CITY OF ALBUQUERQUE

June 25, 2013

**Re: Albuquerque Sporting Center, Tract A-1, Albuquerque West Unit 2
Grading and Drainage Plan,
Engineer's Stamp dated 6-05-13 (C13/D029)**

ENGINEER'S SEAL	PRIMROSE SCHOOL OF NW ALBUQUERQUE	DRAWN BY pm
	GRADING PLAN	DATE 3-20-18
		DRAWING
		SHEET # 4
		JOB # 2017092

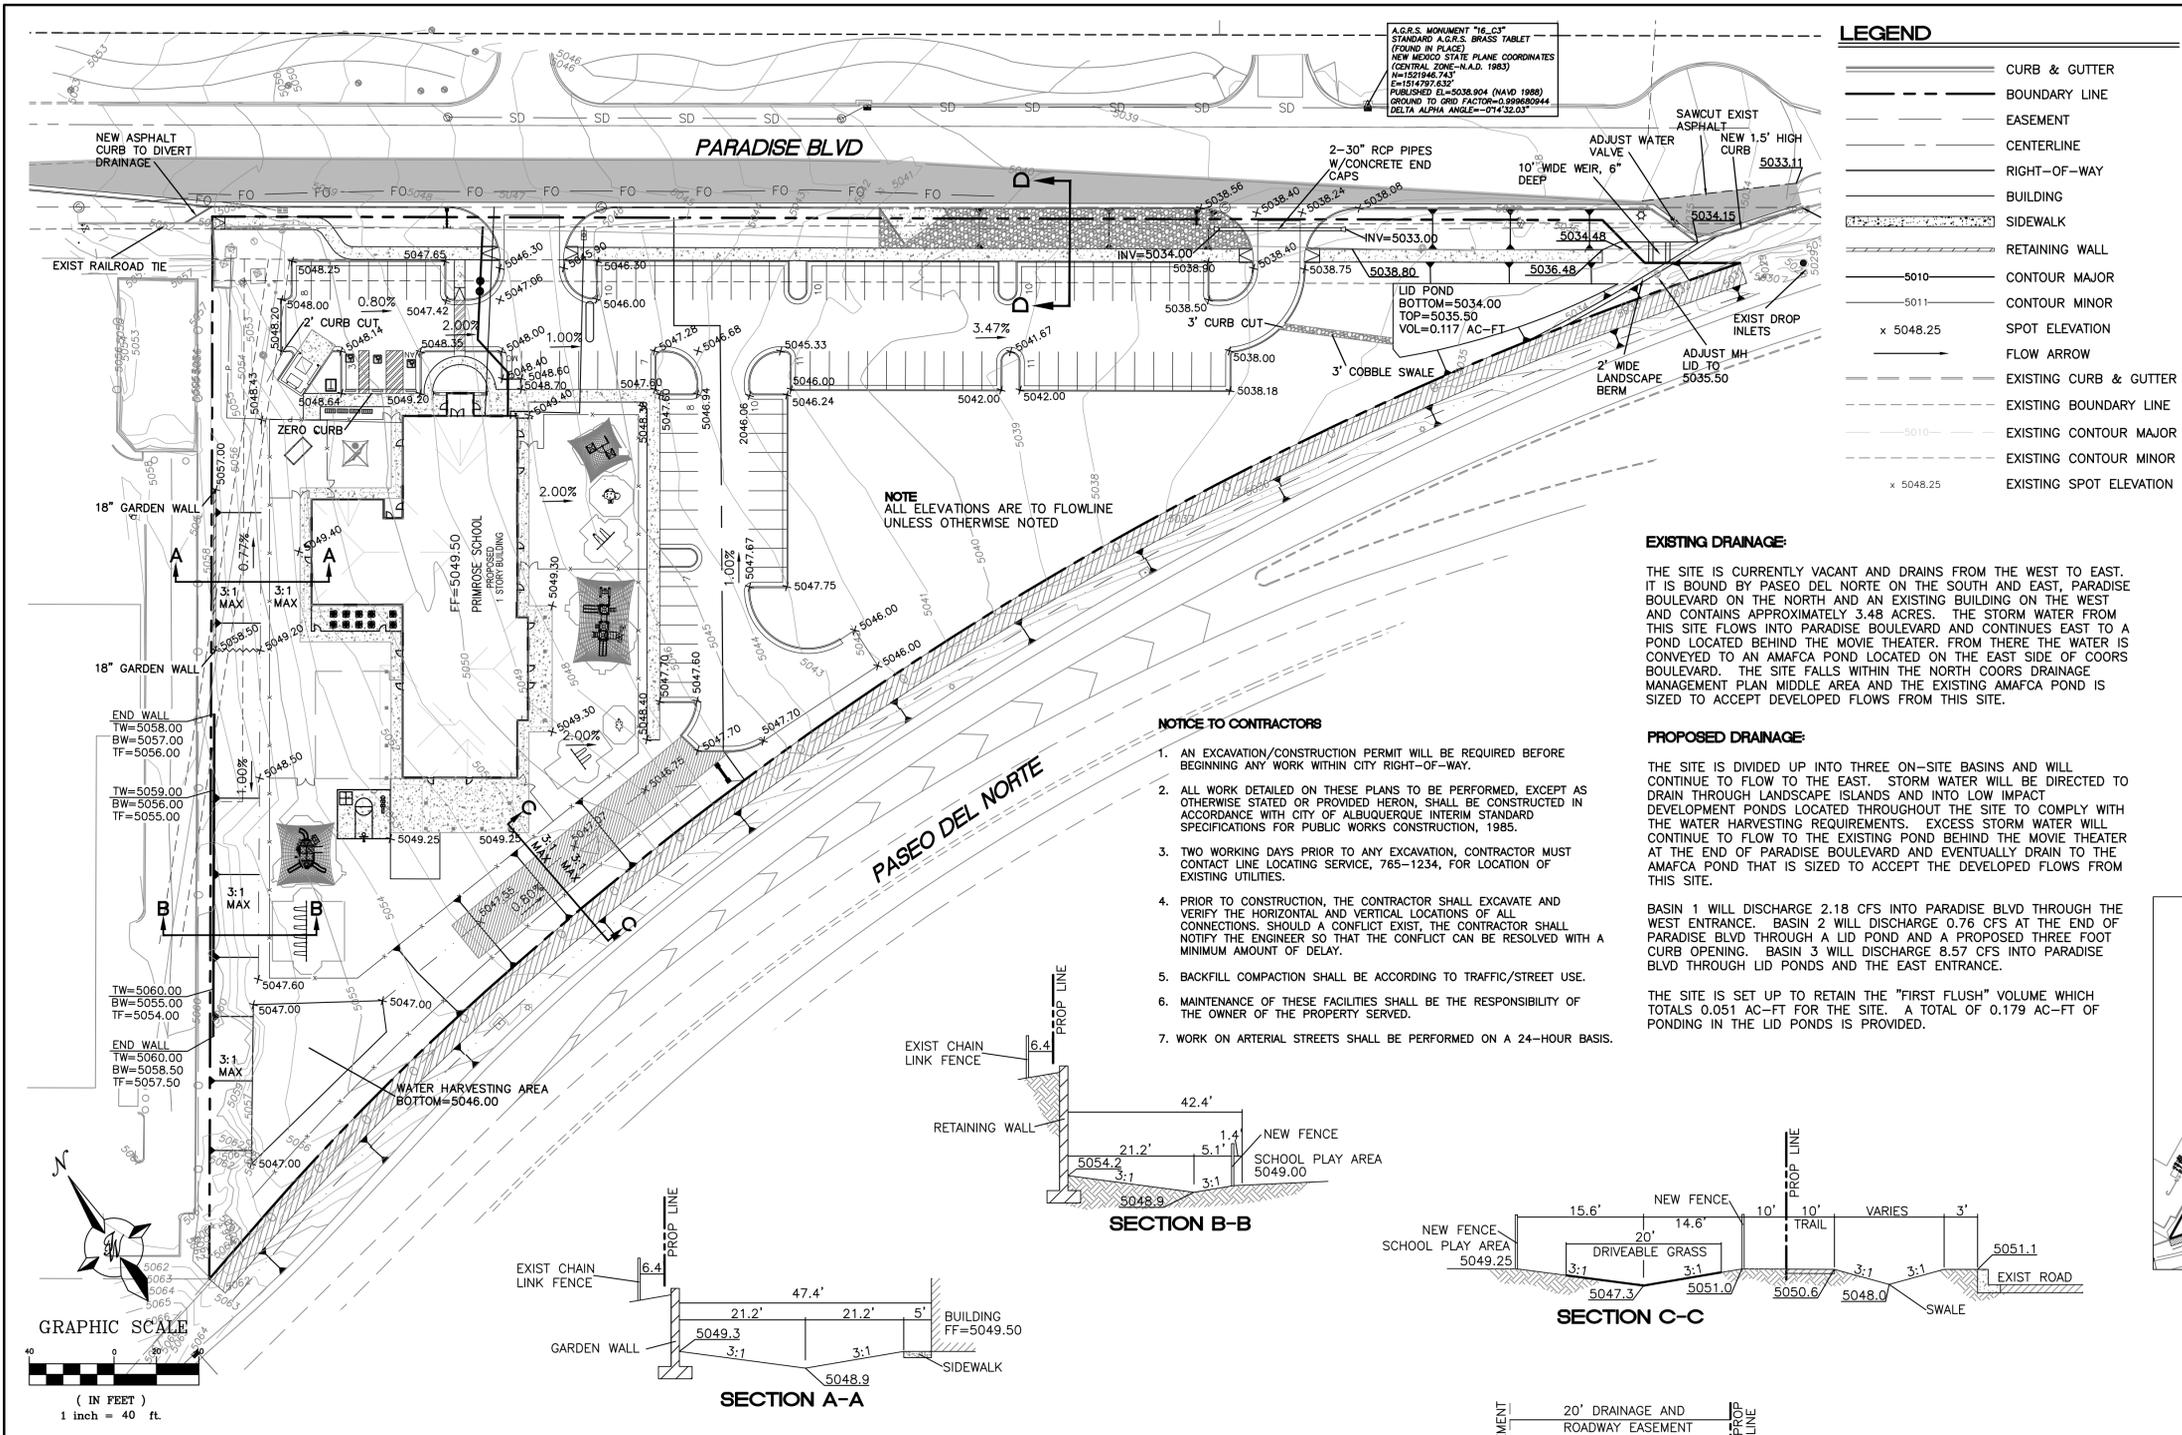
Based upon the information provided in your submittal received 6-6-13, the above referenced grading and drainage plan is approved for Phase-I Site Plan for Building Permit and Phase-I Building Permit only. The following comments have to be addressed prior to approval of Phase-II:

- The proposed 30' curb opening along Paradise Boulevard may be a safety issue. If so, an alternative design would be required to intercept the runoff. Provide calculations for the 30' opening.
- Section B-B drainage calculation is shown to have a 1.44' water depth, but the section shown on the plan only calls out for a one foot high curb. The cul-de-sac and the entrance to the concrete channel should be modified to intercept all the runoff.
- It is not clear how the cobble swale or the lid pond drain out into the cul-de-sac. A 40' curb opening calculations was provided. Show the location of the 40' curb opening on the plan.
